Response to Planning application from Hertfordshire County Council (T and CP GDP Order 2015)

District ref: 6/2021/0072/MAJ
HCC ref: WH/5393/2021
HCC received: 25 January 2021
Area manager: Matthew Armstrong
Case officer: Samuel Tearle

NORTHAW HOUSE COOPERS LANE NORTHAW POTTERS BAR EN6 4NG

Repair, refurbishment and conversion of Northaw House to form 11 apartments (including refurbishment of existing single caretaker's flat) and underground parking area, the Ballroom Wing to form 2 dwellings, the Stable Block to form 1 dwelling, refurbishment of existing dwelling at Oak Cottage, construction of 2 new Gate Lodge dwellings, 4 new dwellings on the East Drive, 3 new dwellings within the Walled Garden, 7 new dwellings within the Settlement Area, refurbishment of the Walled Garden, refurbishment of access routes and reinstatement of old route, provision of hard and soft landscaping, car parking and supporting infrastructure.

Drawing Ref KMC001 - 01 (Sheet 2 of 2)	Rev 02
---	-----------

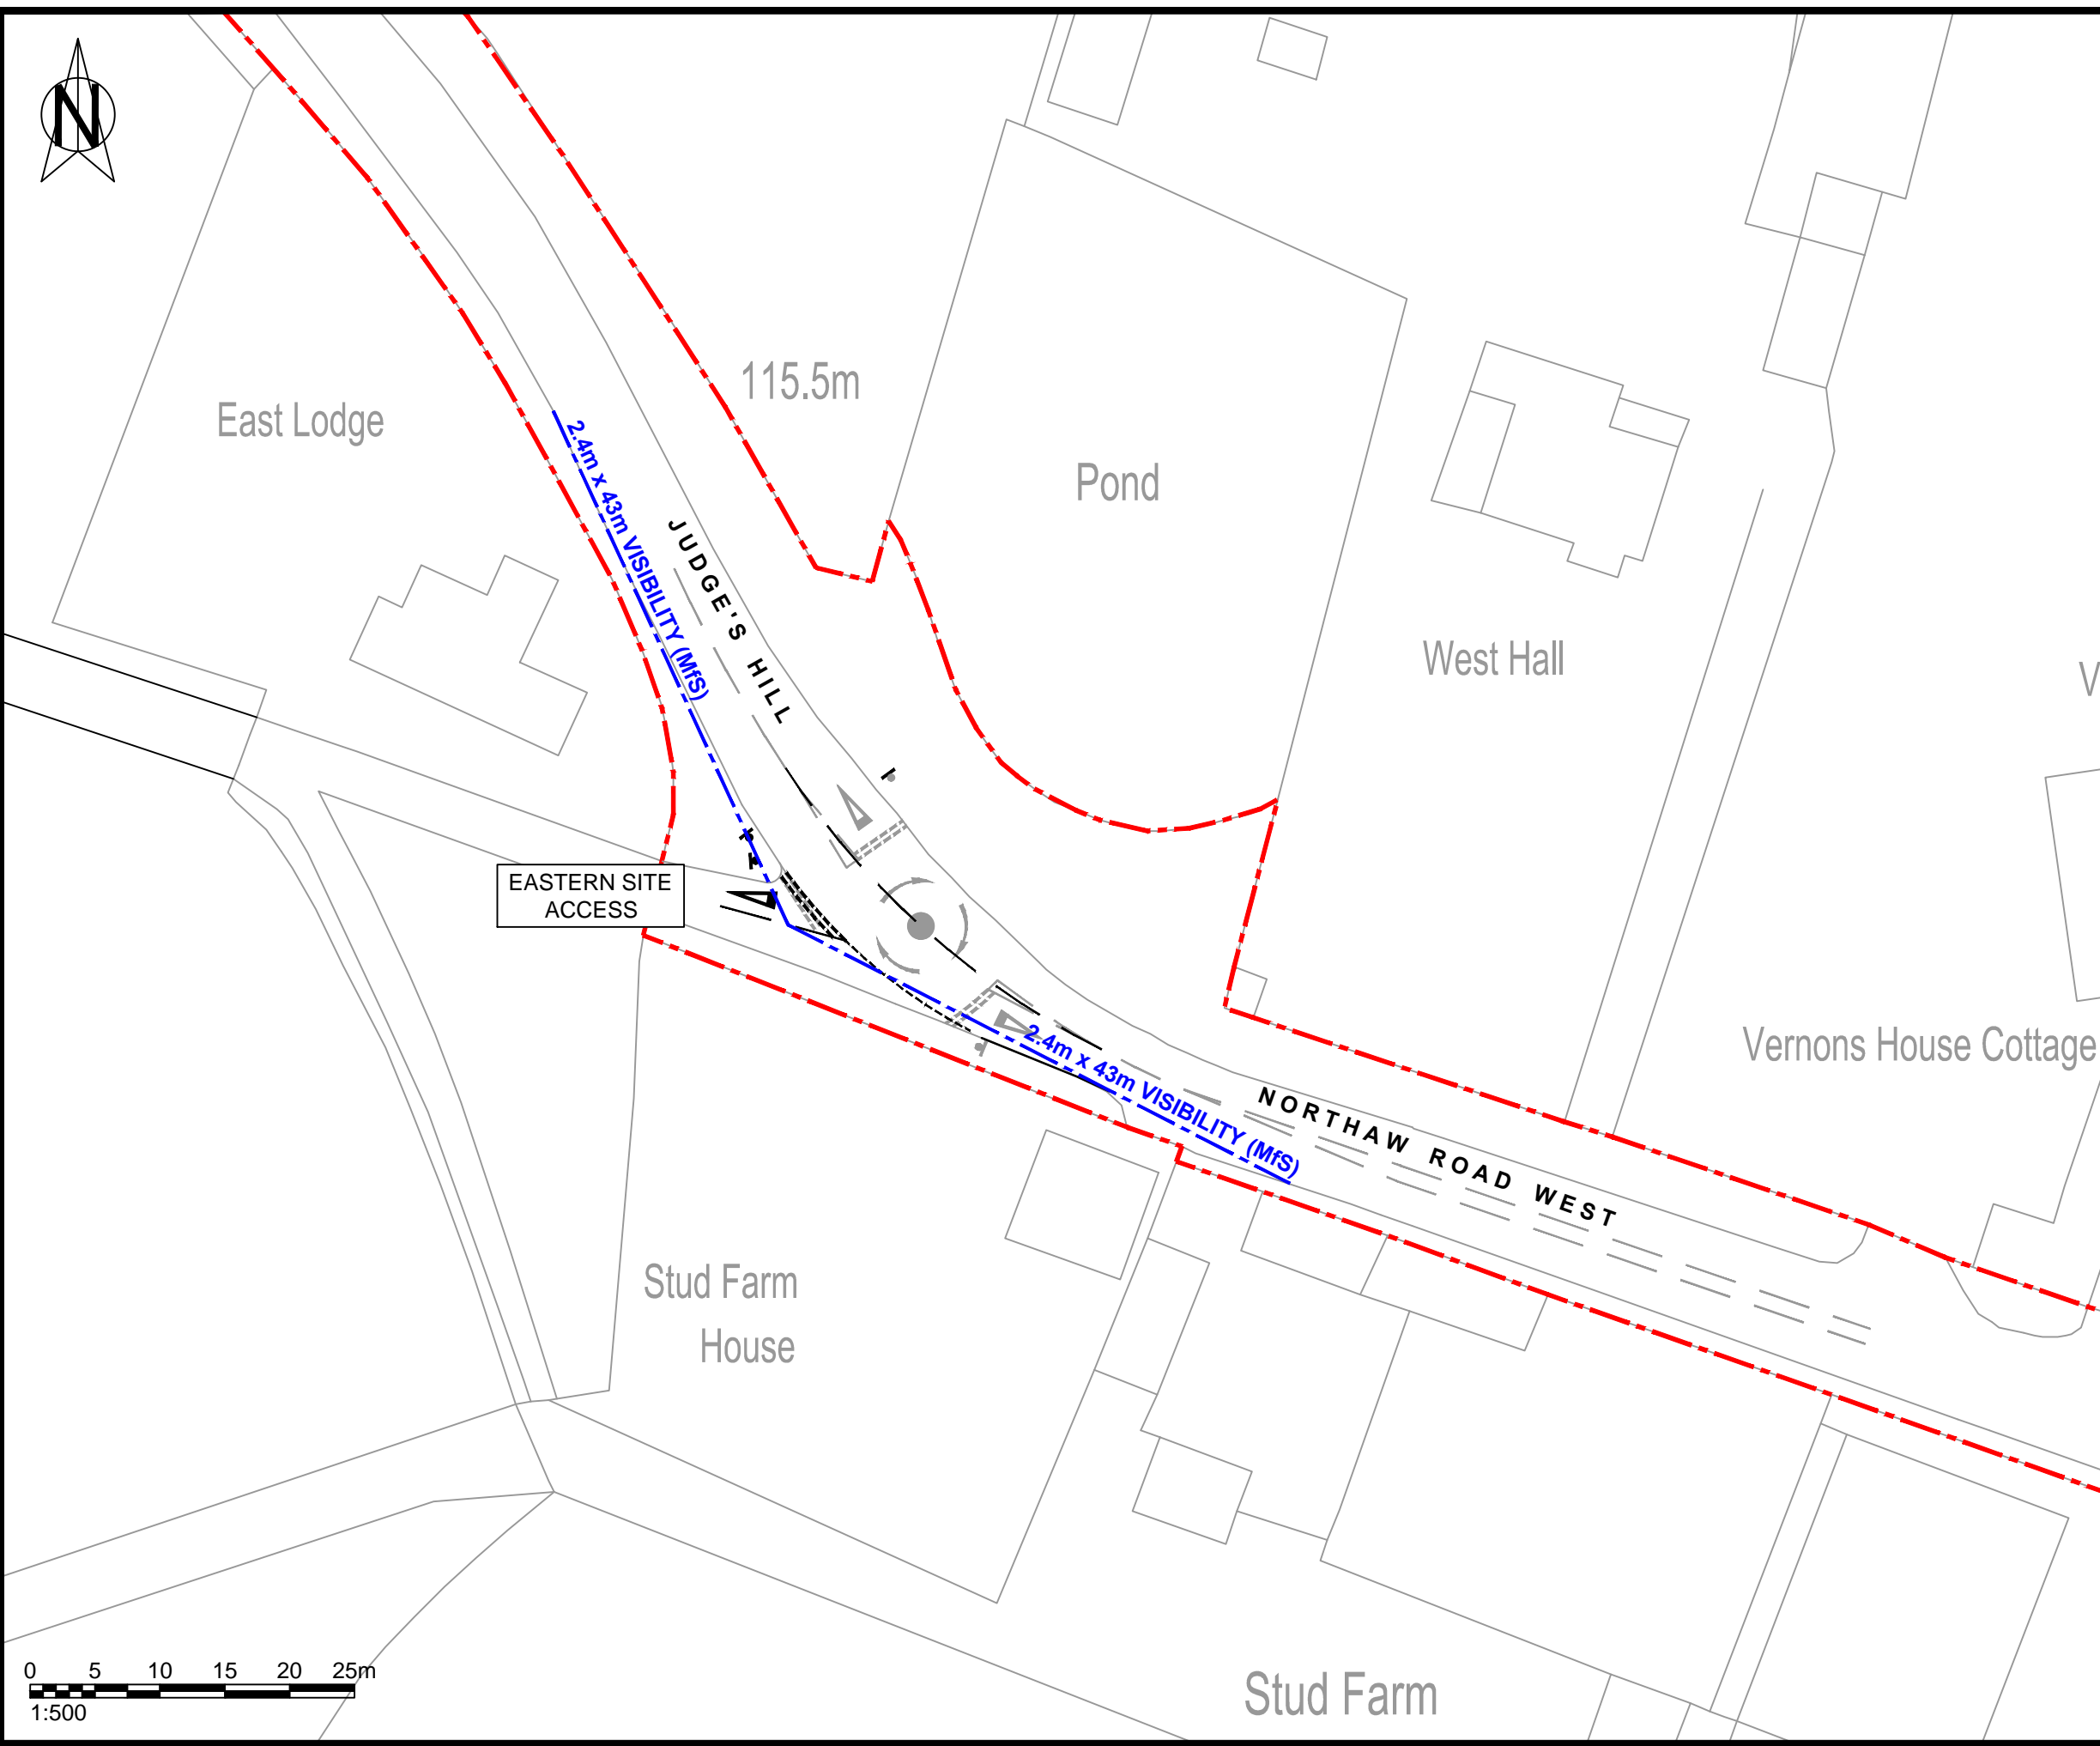
3) Prior to the first occupation of the development hereby permitted a visibility splay shall be provided in full accordance with the details indicated on the approved plan number (KMC01 rev 01 and KMC02 Rev 01). The splay shall thereafter be maintained at all times free from any obstruction between 600mm and 2m above the level of the adjacent highway carriageway.
